CITY OF ALBUQUERQUE

**Re: KFC / Taco Bell - West Central, 6810 Central Ave SW,
Permanent Certificate of Occupancy (C.O.)
Engineer's Stamp dated 12/13/06 (K-10/D025B)
Certification dated 09/12/2007**

Based upon the information provided in your submittal received 9/12/07, the above referenced certification is released for Permanent Certificate of Occupancy by hydrology.

KFC WEST CENTRAL GRADING & DRAINAGE PLAN

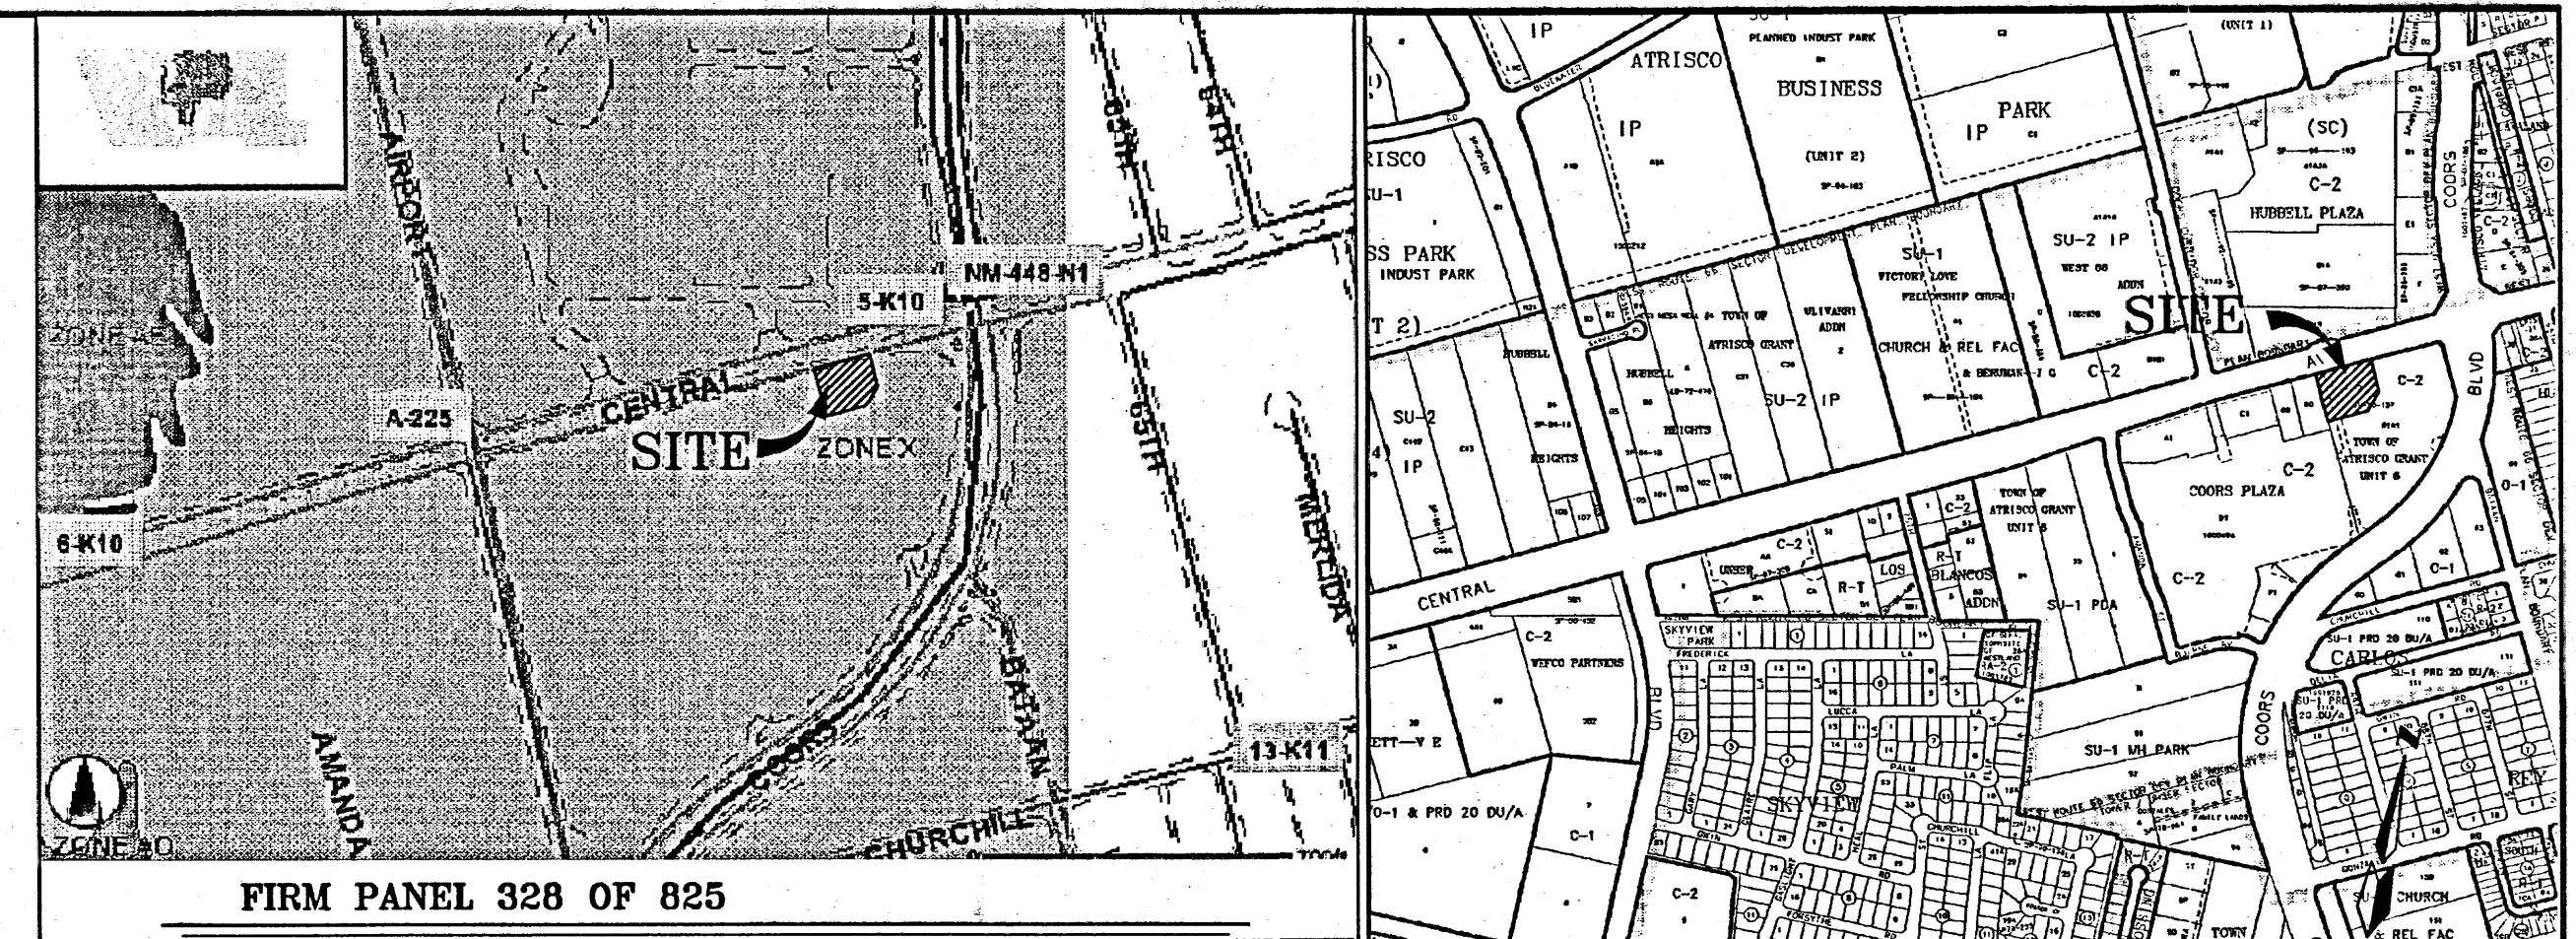
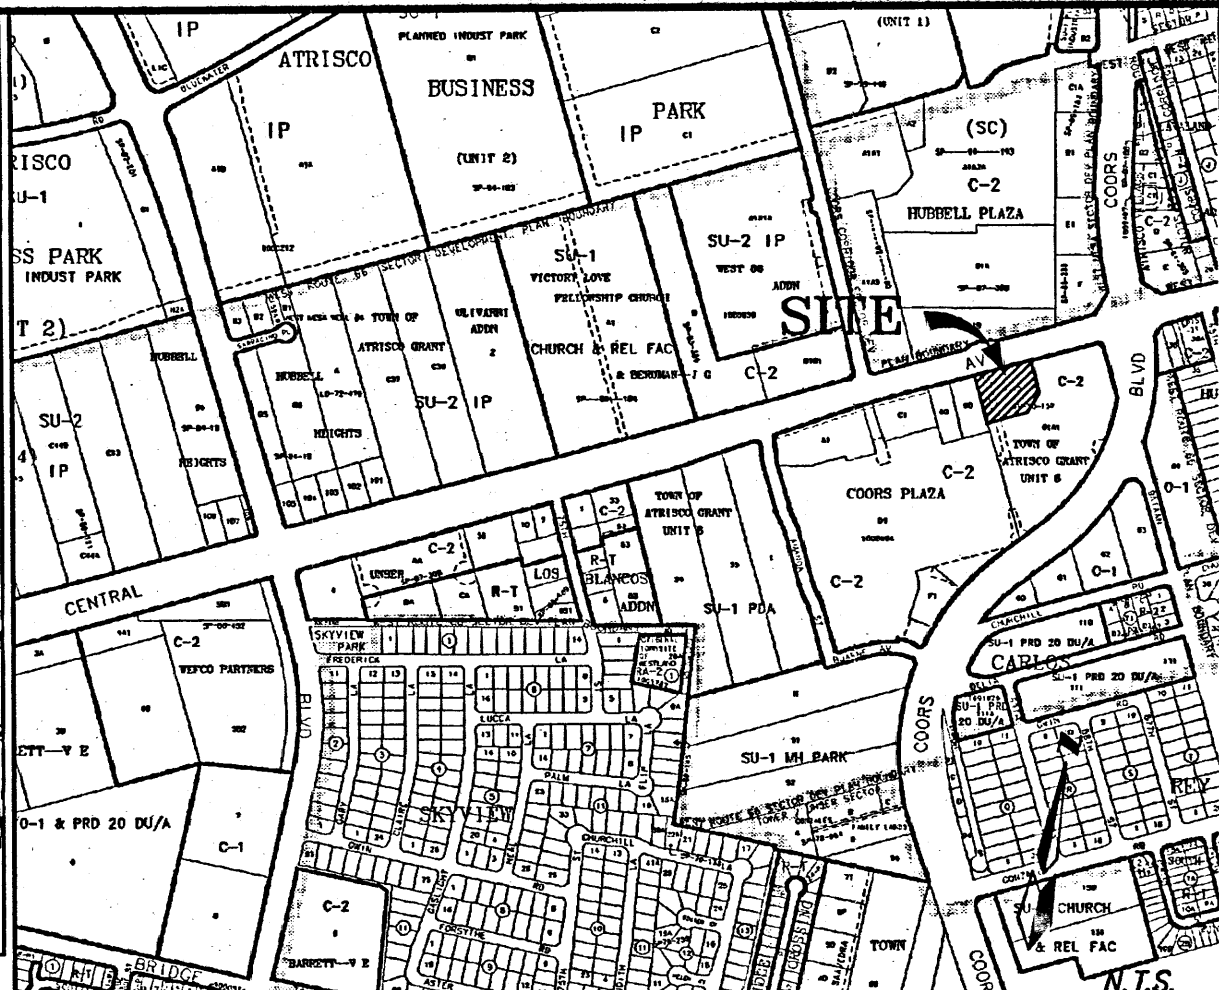
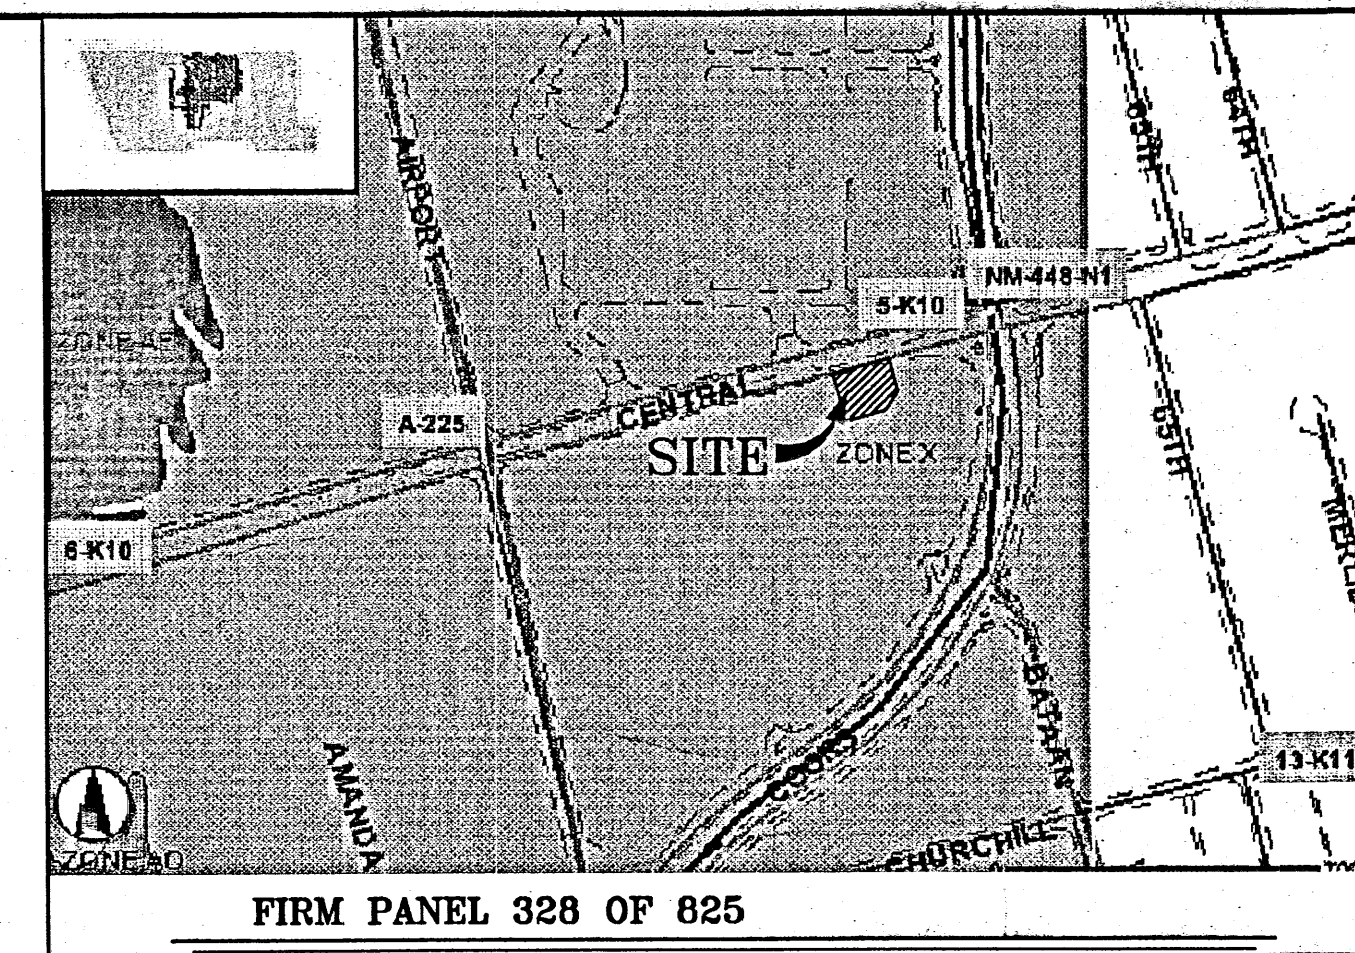
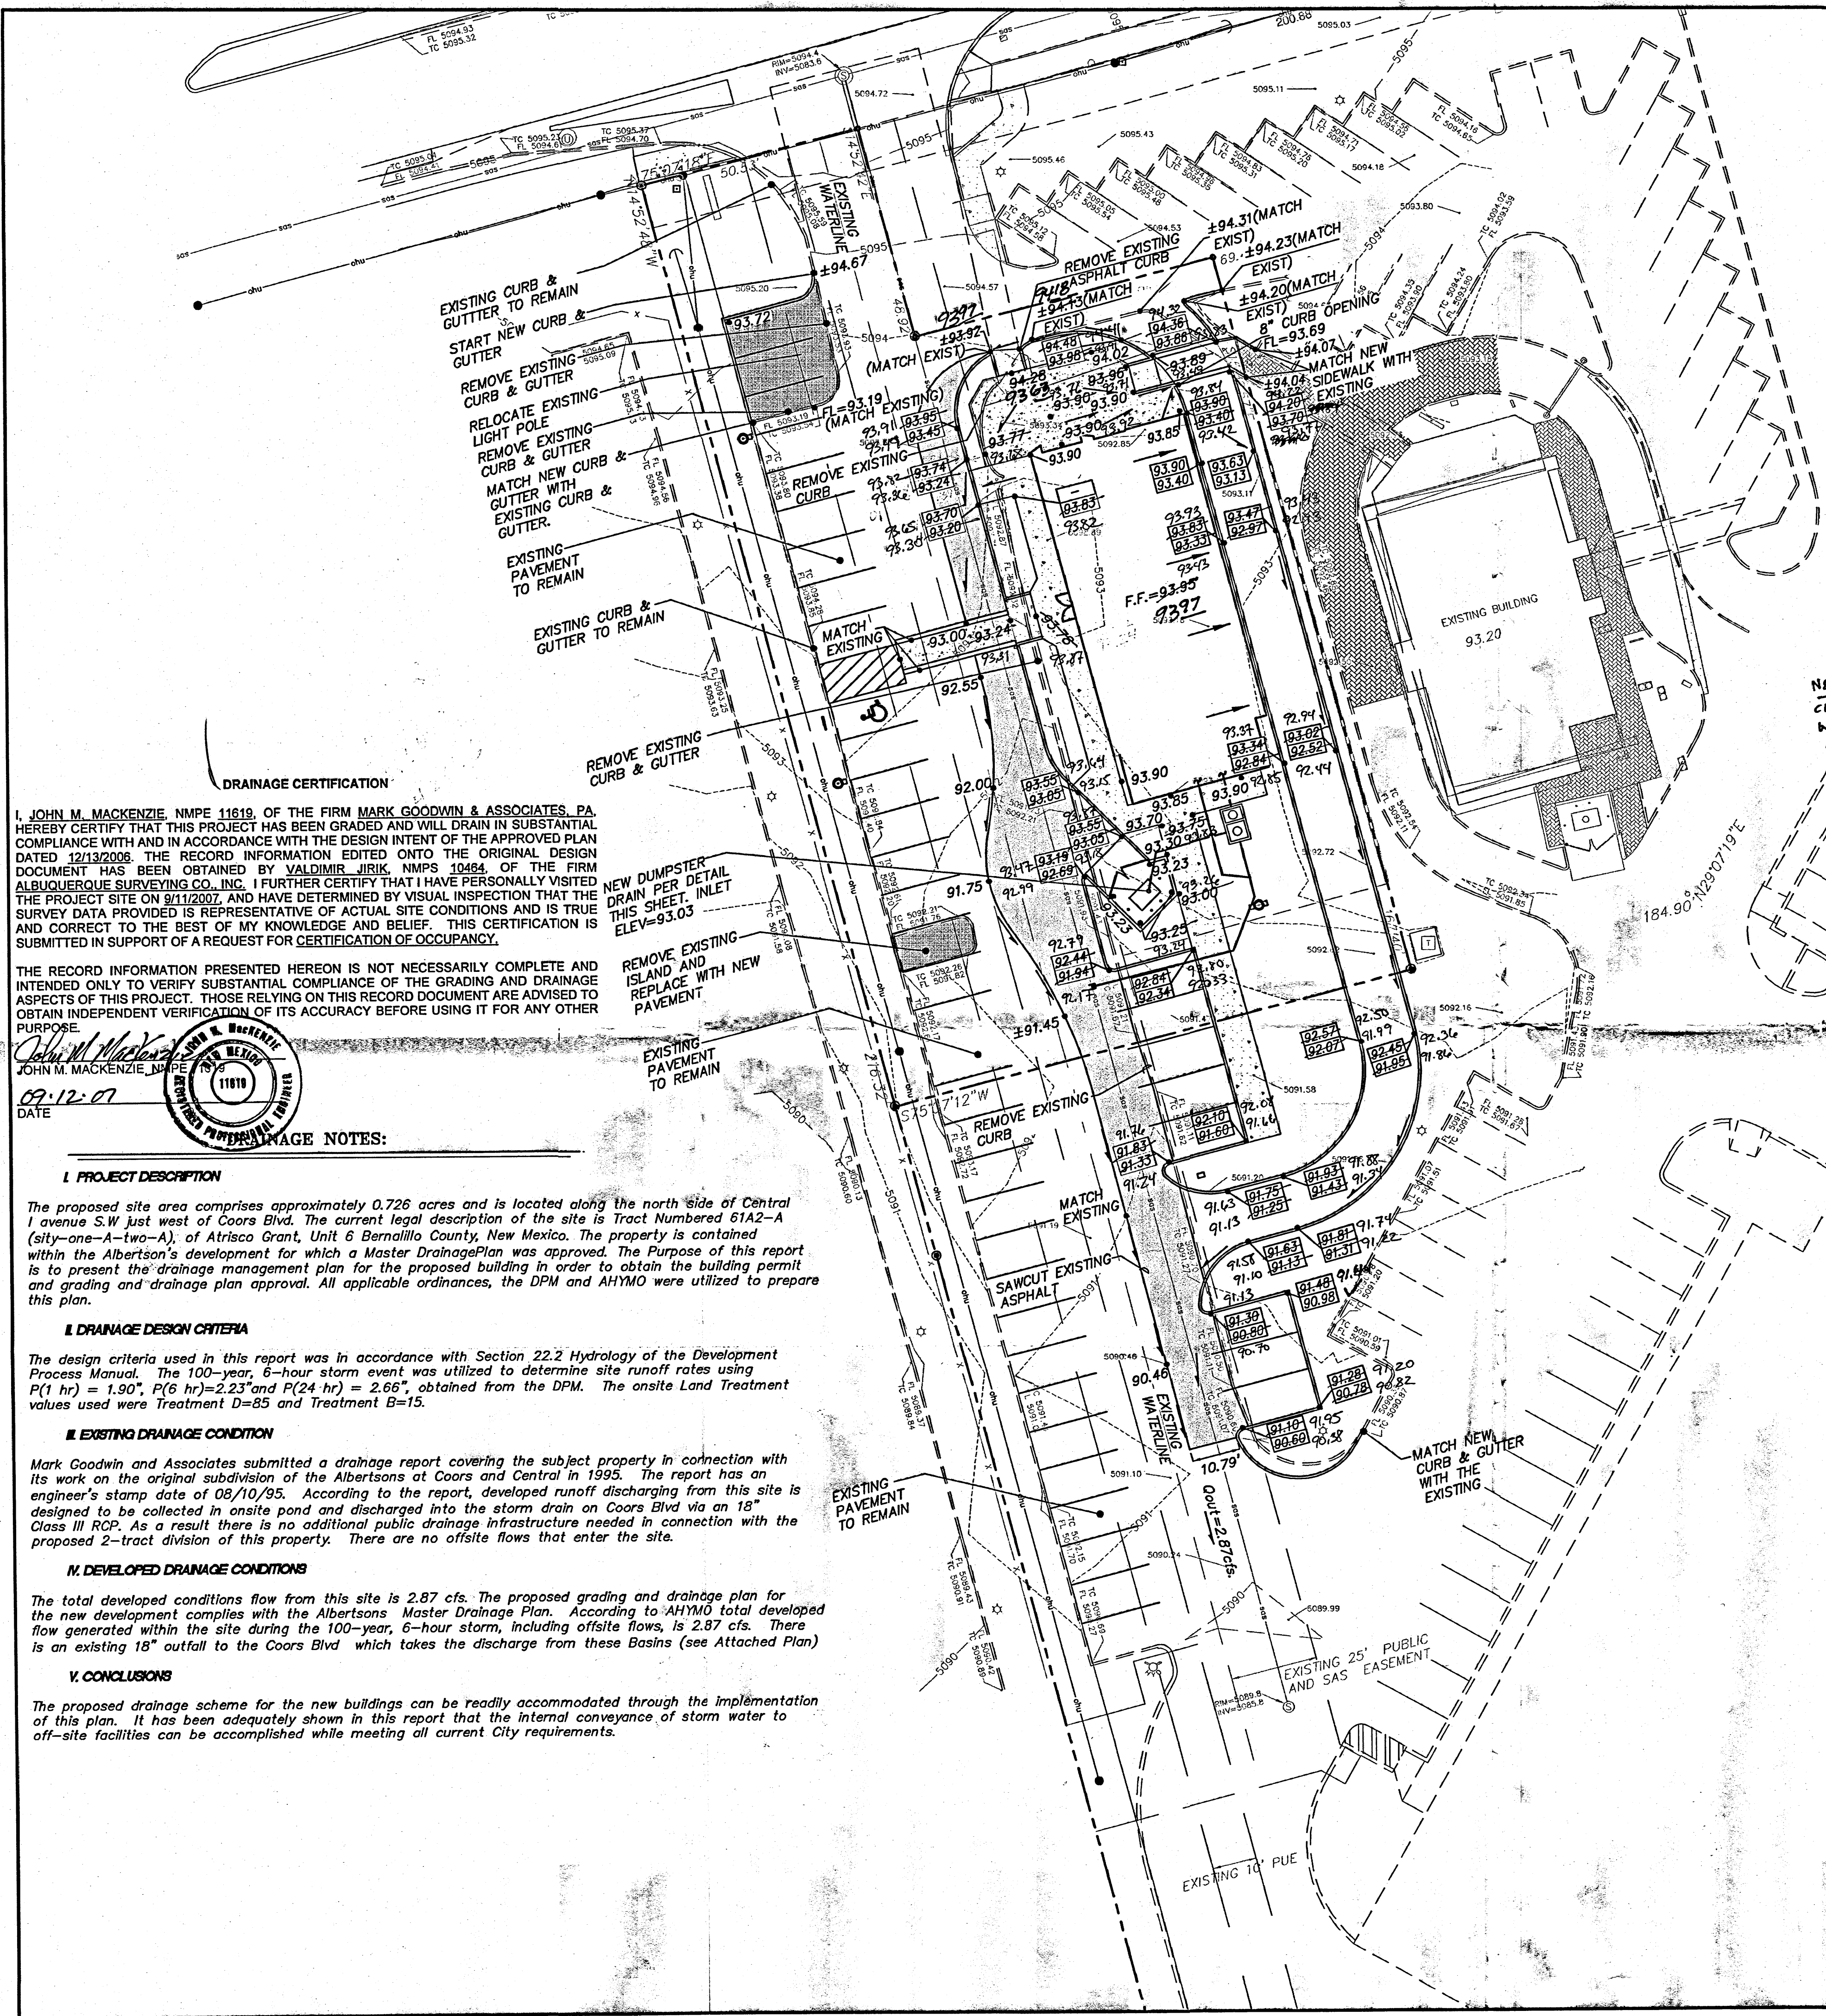
- The legal description cited in your legend does not match the description in the drainage notes.
- Please revise the labels on your scale.
- Please provide the stamped, site-specific runoff calculations for this development.
- Runoff from dumpster enclosures may not be routed into storm drains. A drain to the sanitary sewer collection system is necessary. Please provide a detail with the associated spot and grate elevations along with a drain line to comply with this requirement.
- With your revised plan, please make sure that **all** elements of the plan are sufficiently weighted and darkened enough to be legible.

- We have matched the legal description in drainage notes with one in legend.
- We have revised the labels on the scale.
- We have provided the stamped drainage calculations for the proposed development. (Attached Ahymo printout)
- We have shown the detail as how we are draining the dumpster. The drain from dumpster is connected to the sewer line as shown on the plans with 4" pipe. (attached a pdf file).
- We have made sure that all the line weights are darkened enough to be legible.
